Little Glebe, Little Heath Road, Fontwell

Surface Water Drainage Statement

This application is a re-submission following the refusal of AL/83/19/DOC.

Front Soakaway
Detail SA01

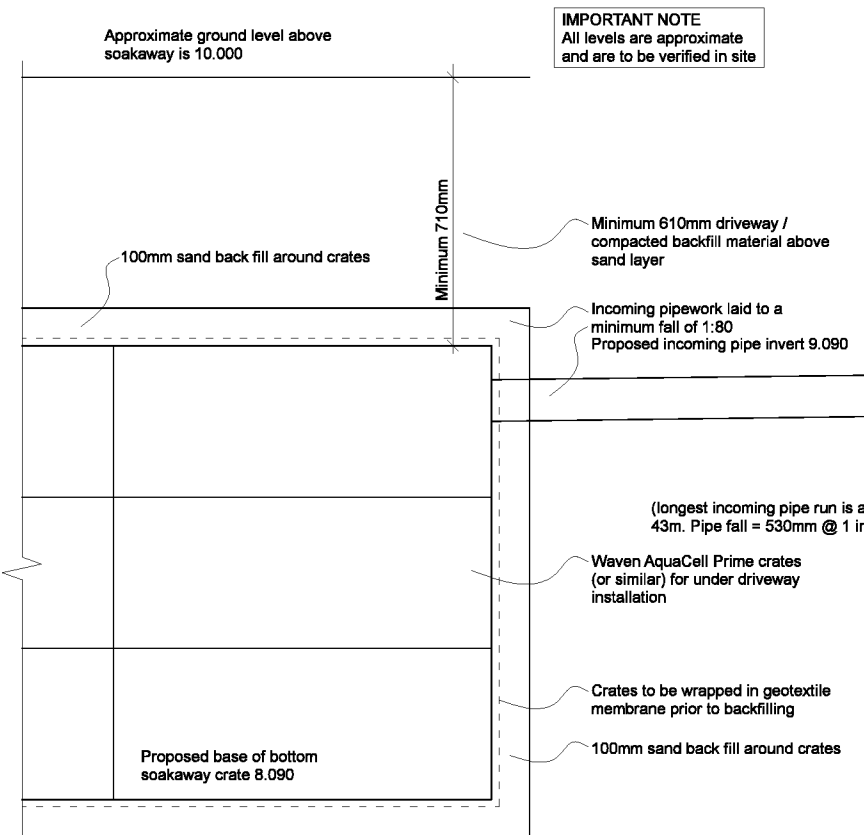
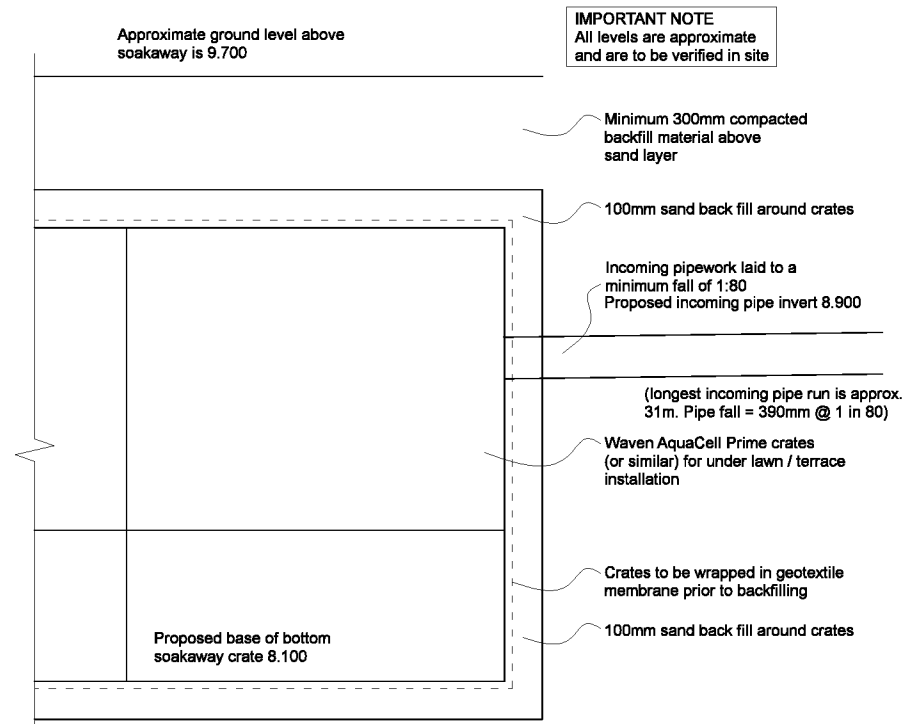
“There are still errors within the report, whereby the front soakaway comes up undersized (as despite quoting a rainfall ratio r of 0.35 it seems that the Z1 values relate to a ratio of 0.42, this gives a lower inflow resulting in a lower required storage volume). However, in this case I am confident that the small surplus volume can be accommodated within the pipes and manholes conveying surface water to the soakaway.”

The design as now submitted has been agreed in principle. The following comment from Ms Burrows is to be noted:
